# CITY OF ALBUQUERQUE

July 27, 2021

**RE: 13500 Trail Vista Court NE**  
**Grading and Drainage Plan**  
**Engineer's Stamp Date: 07/08/21**  
**Hydrology File: F23D010D**

A PROPOSED PLAN
FOR
13500 TRAIL VISTA COURT N.E.
ALBUQUERQUE, BERNALILLO COUNTY
NEW MEXICO
APRIL, 2021

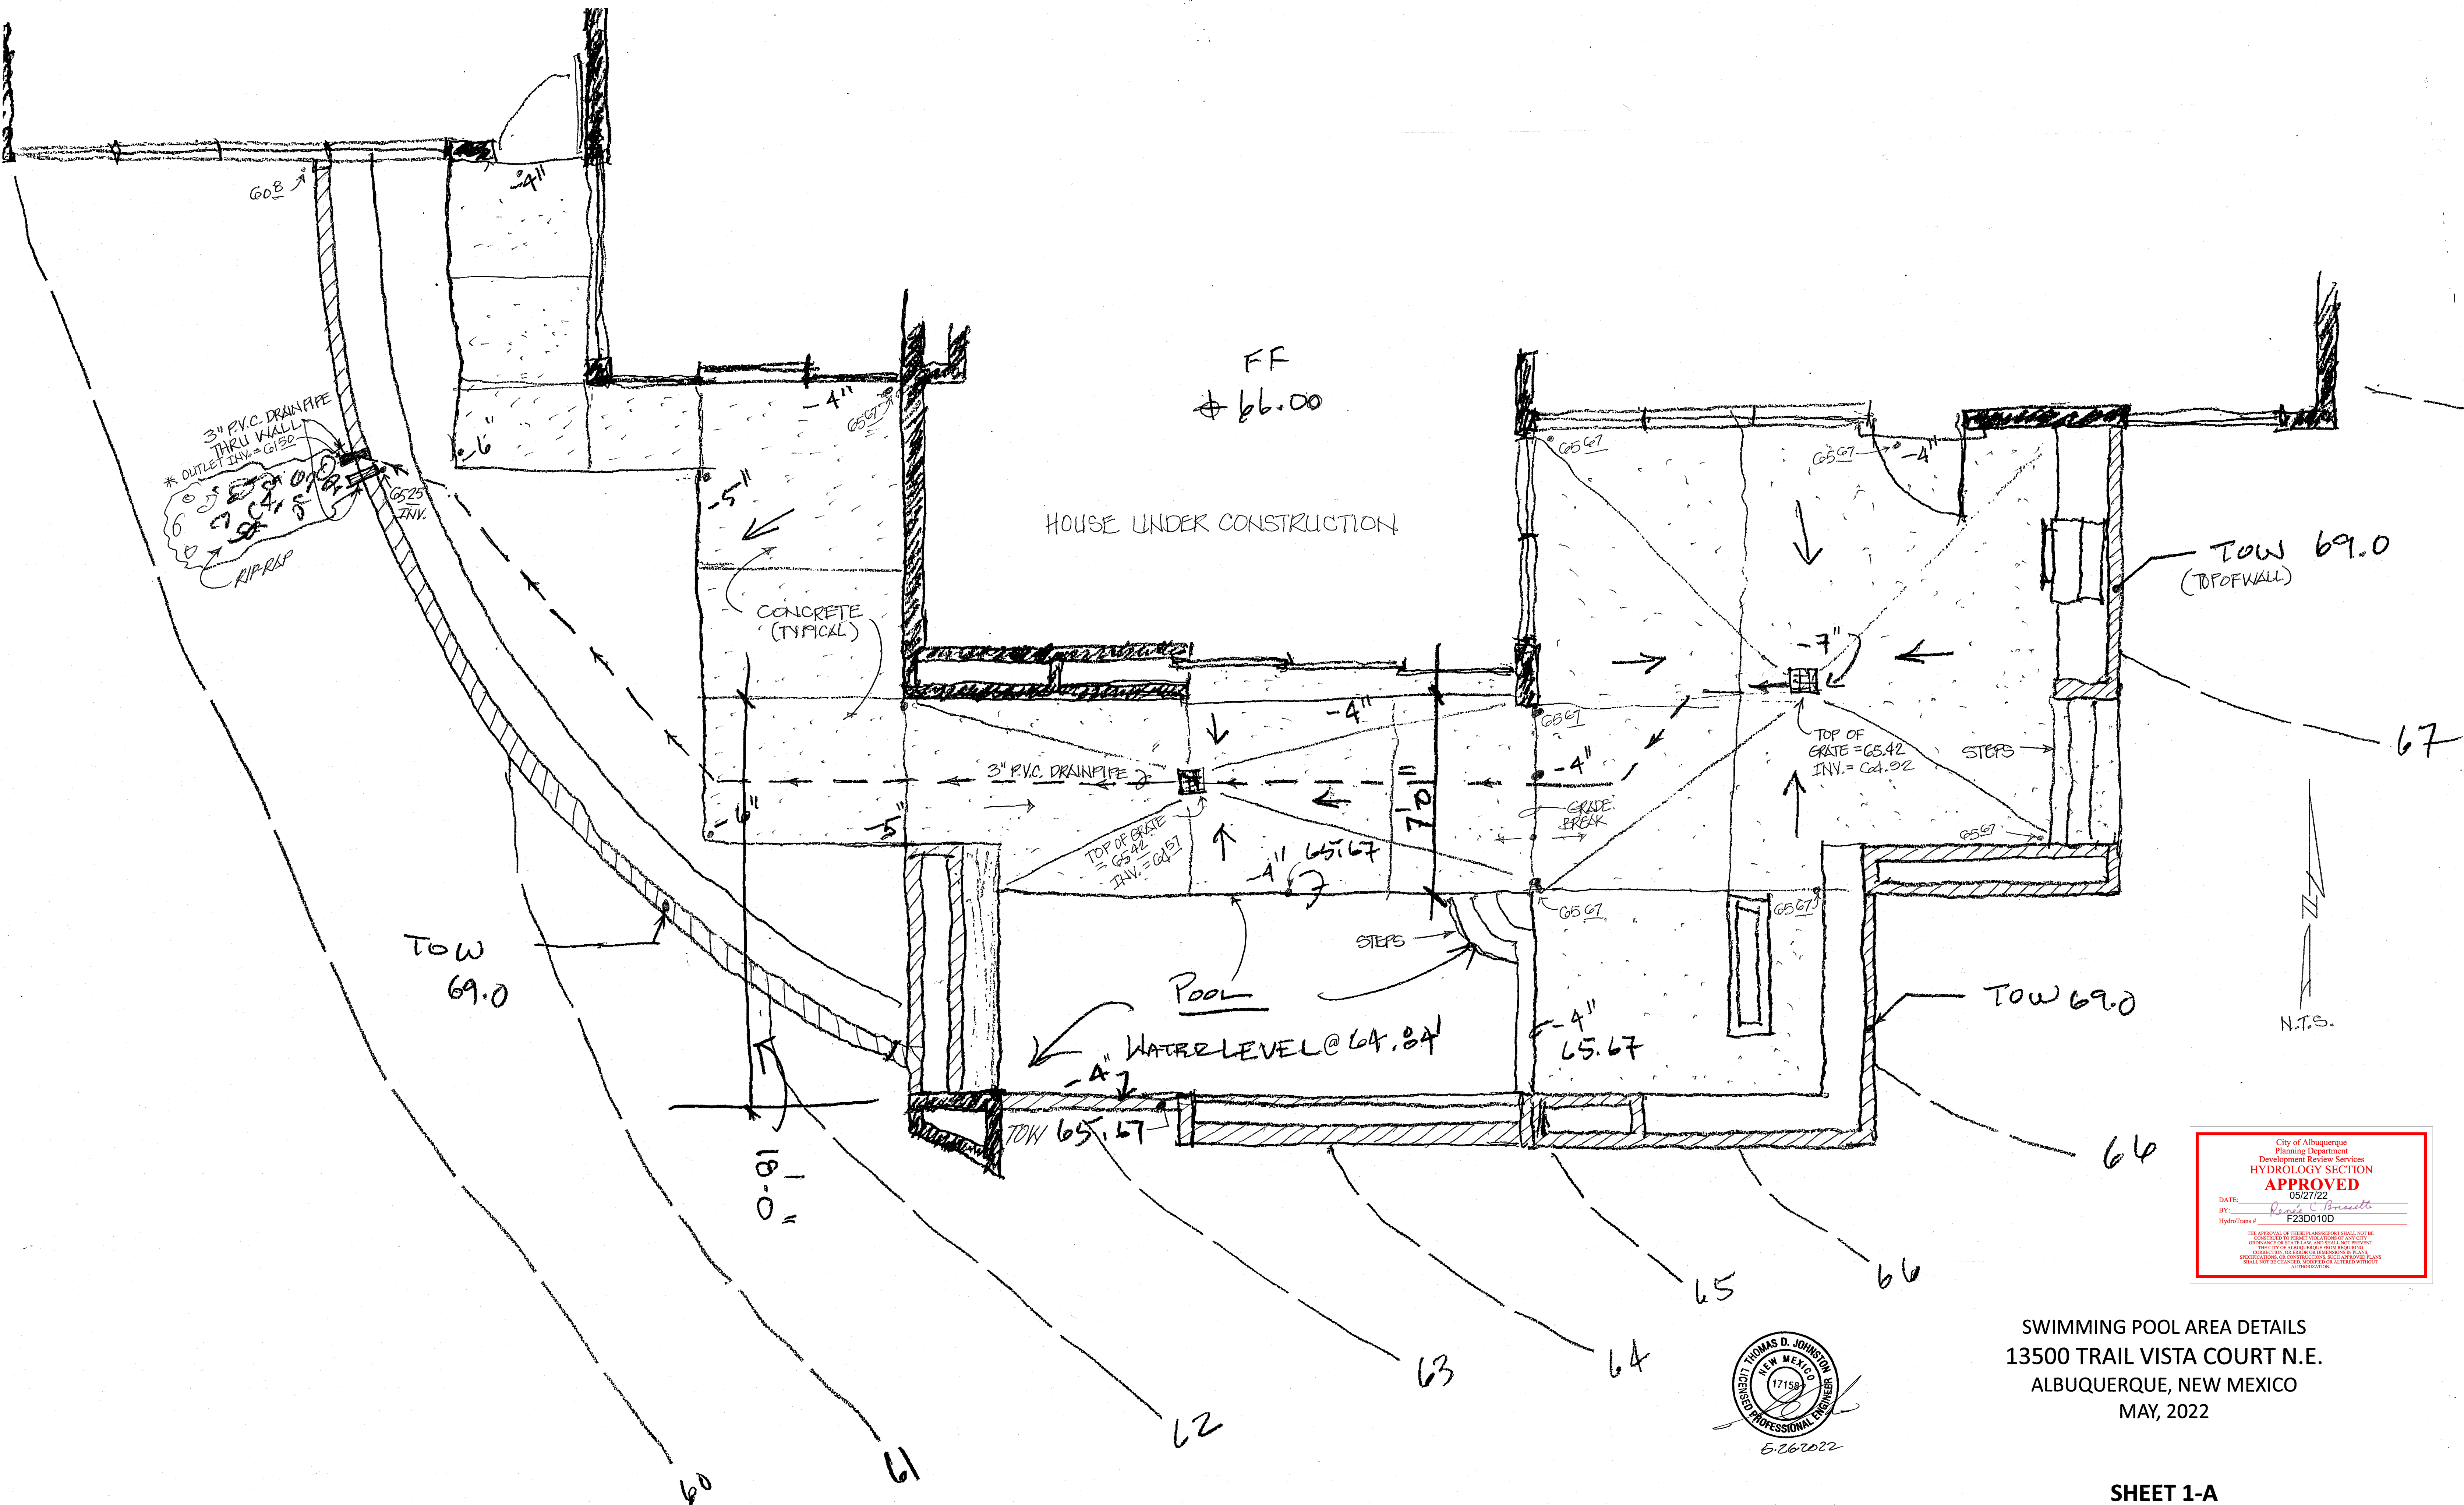
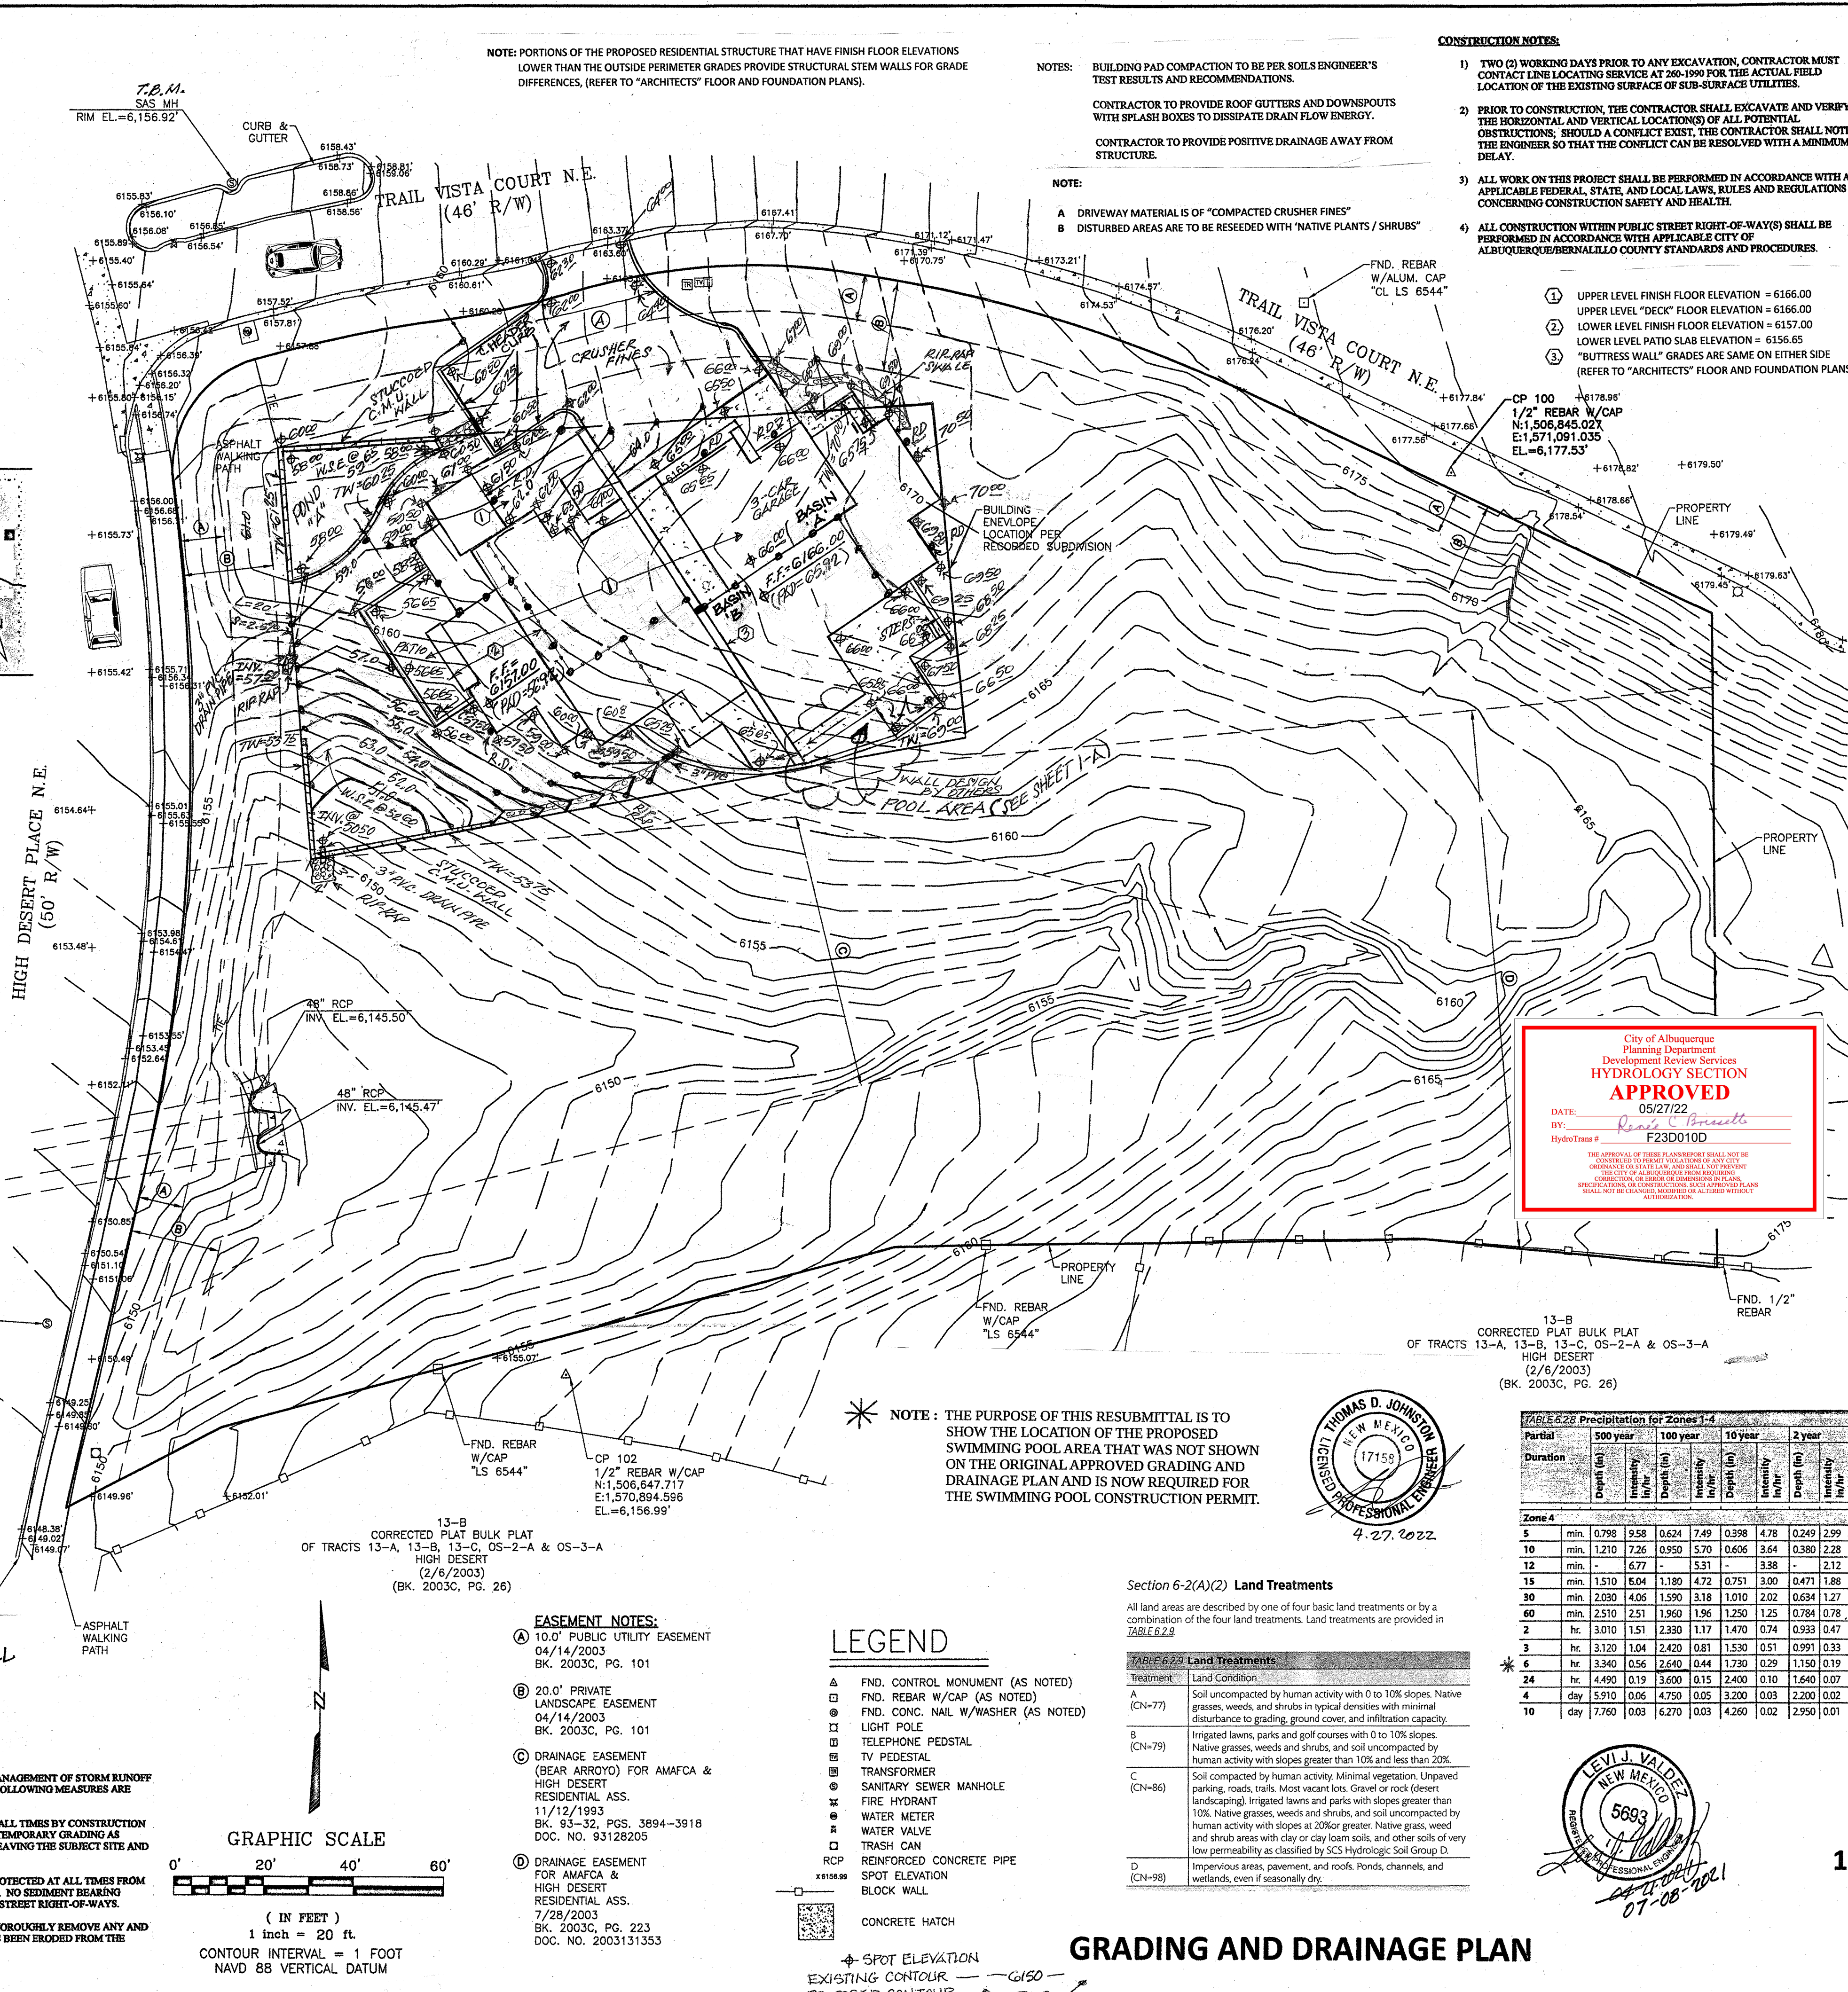
pond should be at least 10' away from home

provide elevation at all corners of curb and opening to ensure proper drainage. provide elevations for curb. there are contours that cross curb with no elevation change

These grades seem funky for a driveway. consider regrading for a smoother driveway surface

not allowed to have home structures outside building envelope

grading and cutting through the PUE is not allowed. You may be exposing or providing inadequate cover for the dry utilities.

1. Locate roof drains  
2. splash pad are required at all roof drain locations  
3. swales shall be required from all roof drains to ponds  
4. what material is driveway  
5. indicate how disturbed area is been treated

label required vs actual. how is drainage being released.

show more detail. FF is 57 yet new grades are 61. How is this draining

provide elevation at all building corners around perimeter of home as well and concrete surfaces to ensure proper drainage away from building

is this a stem wall? How do the grades relate on either side.

grading can not occur in the amafca easement

is this a retaining wall. Label top of grade high and low so it is clear the height of the retaining wall

consider moving pond here to keep in building envelope and keep at least 10' from home.

more than just the building envelope is being disturbed. account for all distributed area in calculations not just the building envelope

site is required to detain the difference between historic and proposed in the 100yr-6hr storm event. A drainage review will occur once calculations have been updated

all runoff must be mitigated through a pond

double check that existing is 100% A. Some areas look steeper
